From: 
Sent: 10 December 2014 10:52
To: 'Douglas Briggs Partnership'
Subject: RE: 6807b: Sefter Farm Applications P/99/14 & P/105/14

This scheme seeks to extend on application P/99/14/L by proposing a further larger addition to the south. The width of the proposed building is such that it results in a higher ridge level, but also appears to produce a structure of considerable bulk and massing. Seen in context with the listed building, it is likely to represent a level of harm to its appreciation and thus its setting.

A more direct impact is the loss of a section of wall and encroachment into the historic farm yard which is evident on historic mapping. This wall is of interest as a farm boundary, as well as being made up of various materials including, flint, brick and what appears to be Bognor rock. Other areas of the wall have already been replaced by brick sections meaning that any surviving sections may be considered to be of greater value.

Proposed
Relocated Retaining Wall Details
September 2014
6807b-104
1:500, 1:20@A3

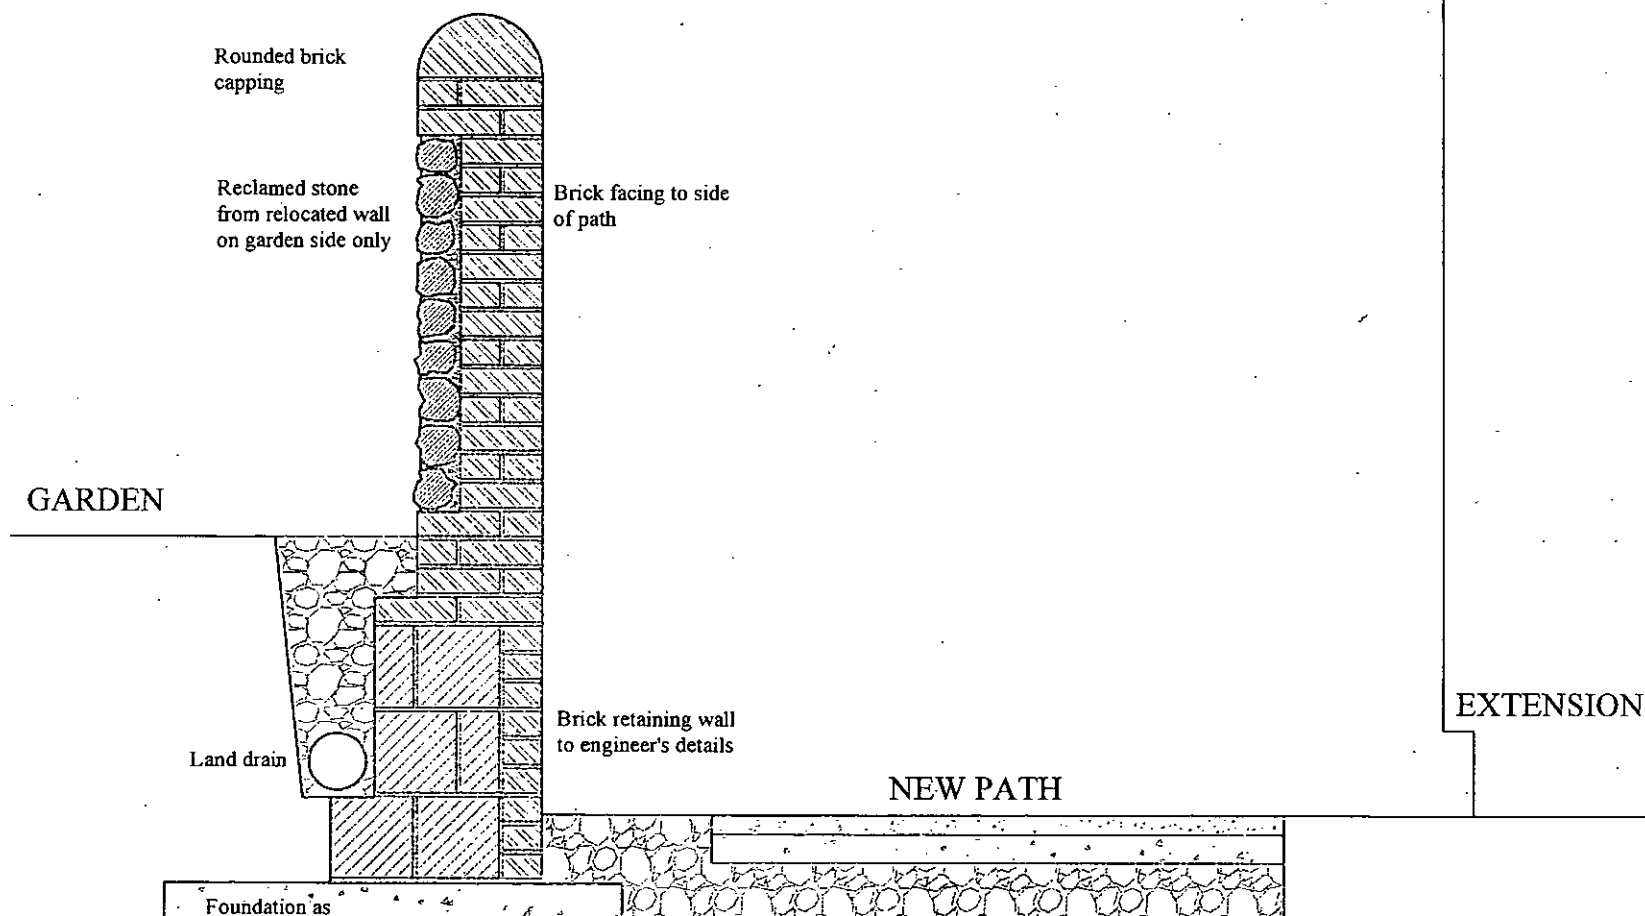
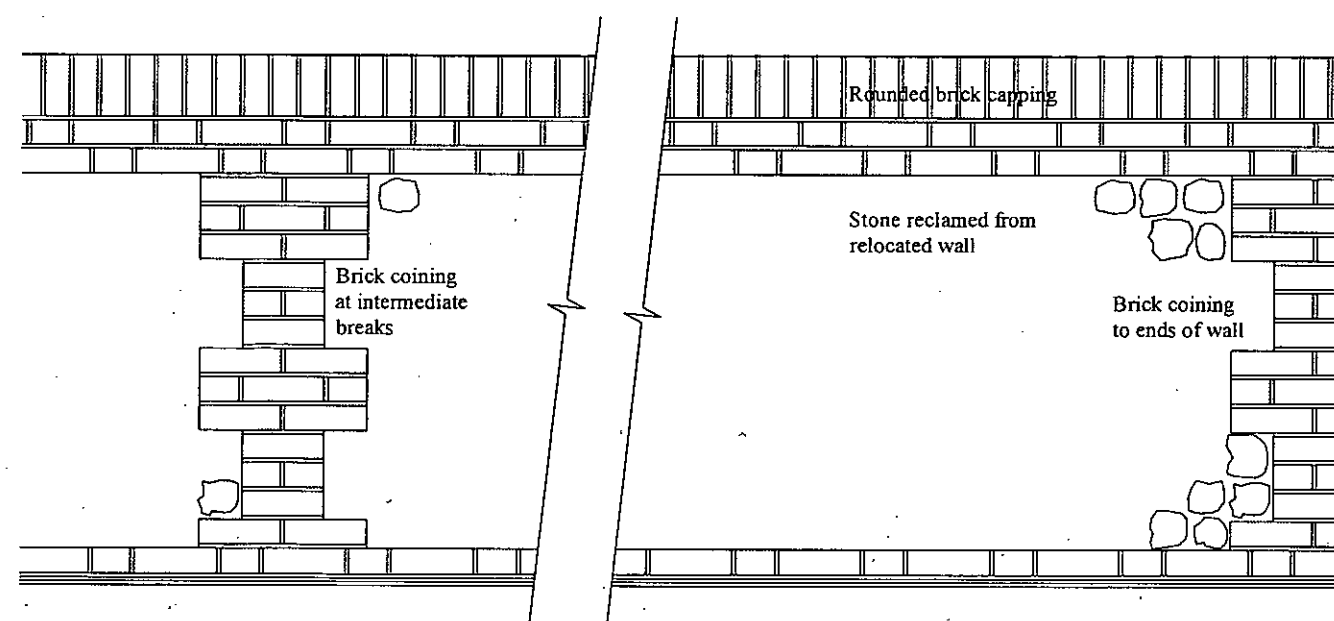
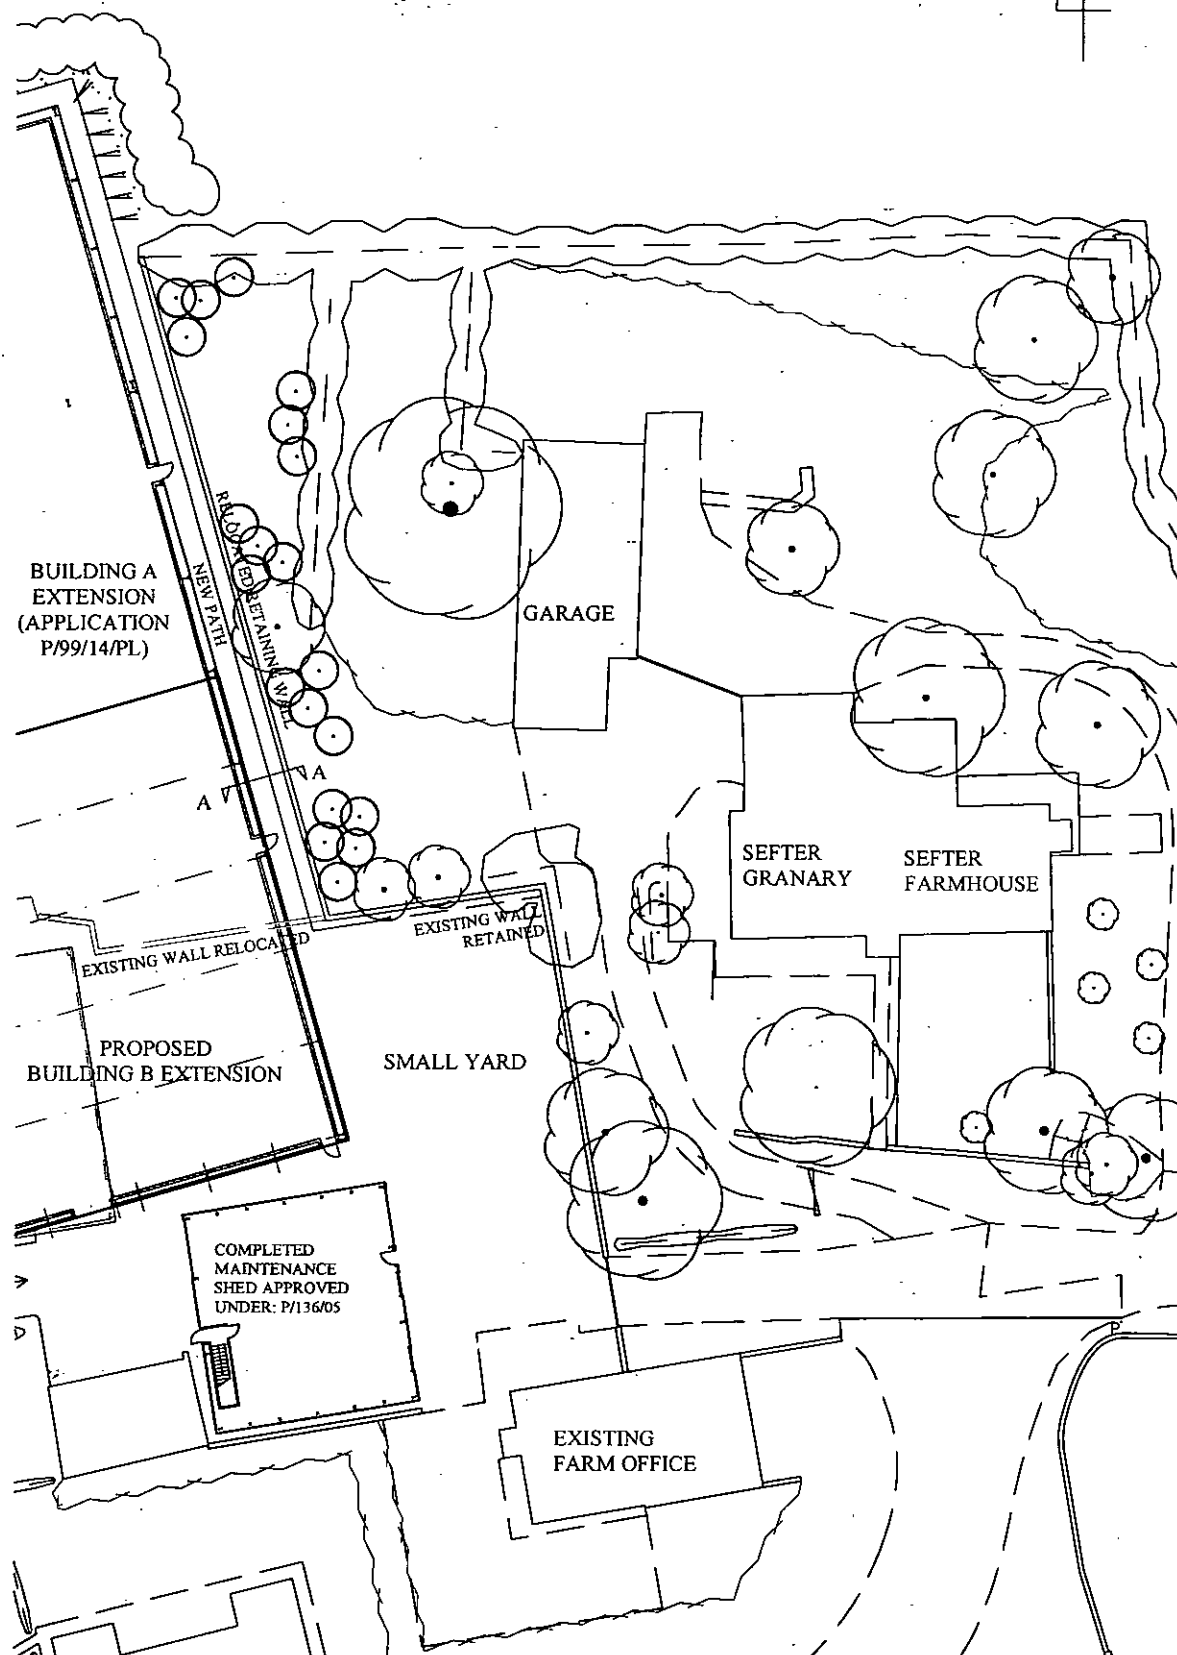
"Thank you for the email and amended drawing which I have discussed with Martyn White and Daniel Vick. Whilst we acknowledge that the material from the historic wall will be re-used, this rarely mitigates harm to the extent that would be required here. As the historic mapping shows, the new building will still encroach heavily into the old farm yard and the scale of it is likely to be significant within the setting of the listed building. To say this does not represent an element of harm (at whatever level) would be negligent on our part and would not meet the requirements of paras 129, 132 and 137 of the Framework. We did have a very useful meeting on site with the MD Mr Julian Marks and he did explain the reasons for the extension so we are aware of the justification. This however would have to be considered in the broader planning balance in terms of potential public benefit etc (para 134 of the Framework)."

Given these concerns, we would suggest a compromise in which the proposed building was reduced to approximately half its size to reduce massing in the setting, but also avoid the loss of the wall and courtyard. A smaller building, or component of the extension could be maintained where the current building is located and would be approximately the same size. This would provide about 75% of the proposed floor area, though obviously less cubic volume. If this is not feasible then justification for the proposal should be considered in potentially broader terms in accordance with para 134 of the Framework."

The revised plan submitted 6807a-101E substitutes the new retaining wall with a bank and fence (relocated from its previous position shown on drawing 6807a-001A) between points B-Y.

The existing wall A-B is shown as demolished on both the initially submitted drawing 6807a-101D and the revised plan submitted 6807a-101E.

As Mr Wightman had suggested in his consultation response, the material reclaimed from this demolition will be used to repair the sections of retained wall from B-C and C-D, as indicated on the revised drawing 6807a-101E.
